**Comments on Responses to the Examining Authority's First
Written Questions**

**for the
Royal Society for the Protection of Birds**

**Application by Alternative Use Boston Projects Limited for an
Order Granting Development Consent for the
Boston Alternative Energy Facility**

Planning Inspectorate Ref: EN010095

TITLE
WHARF GENERAL LAYOUT
DRAWING
FIGURE 5.2 - SHEET 1 OF 3

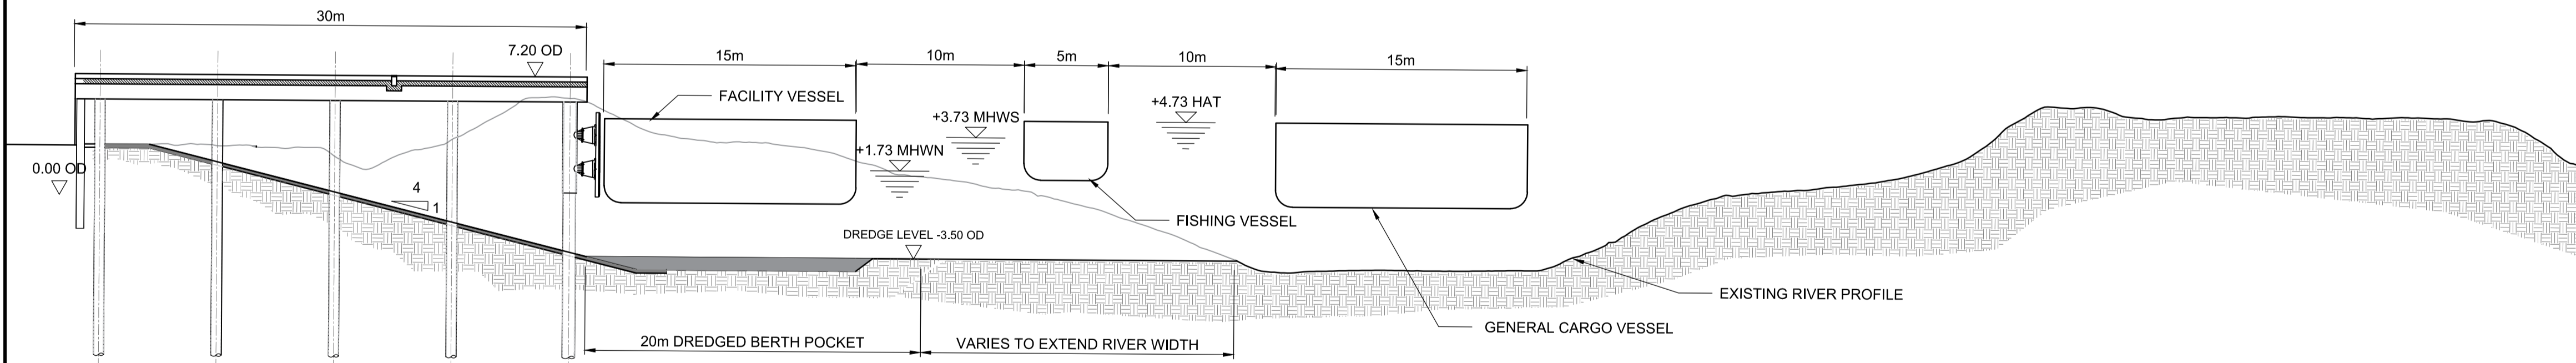
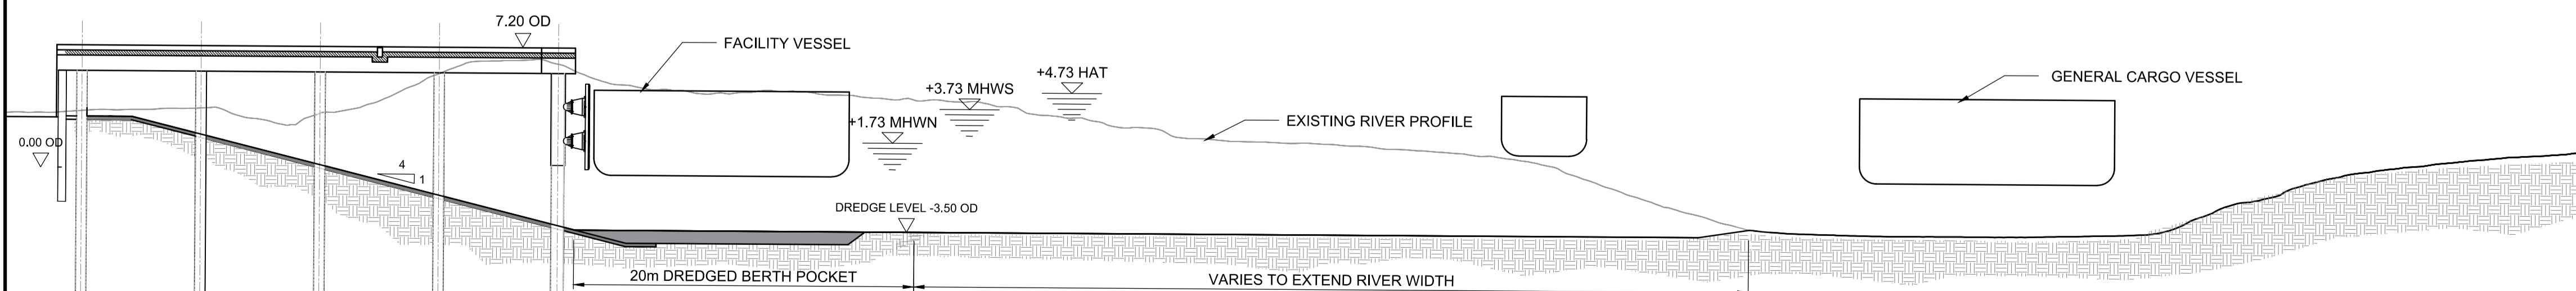
3. Environmental Statement				
Q3.0.5	The Applicant	Please can the Applicant provide examples of the scour protection methods that are likely to be	Depending on river currents it may or may not be necessary to provide scour protection to the river embankment at either end of the wharf, therefore	The Applicant's response suggests that there is a possibility that scour protection will be required. In order

Question number	Question addressed to	ExA question	Applicant's Response	RSPB comments
		used in order to avoid loss of habitats and disturbance, as stated.	<p>this would avoid the loss of habitat and is clearly the preferred solution which would be prioritised under any detailed engineering design. However, if scour protection is absolutely necessary detailed design will include consideration of the following options, with the key design principle being minimisation of habitat loss:</p> <ol style="list-style-type: none"> 1. Articulated precast concrete mattress; 2. Grout injected fabric mattress; and 3. Individual stone/rock armour 	to understand the worst-case implication of the development with respect to habitat loss and impacts on waterbirds and other wildlife using The Haven, it would seem appropriate to base any habitat loss calculations on scour protection being required. There is uncertainty conveyed in the Applicant's response and we recommend that calculations for compensatory habitat creation should include the area that would be impacted by scour protection if required. A range of habitat loss could be presented as a way to address the differences in opinion at this stage.
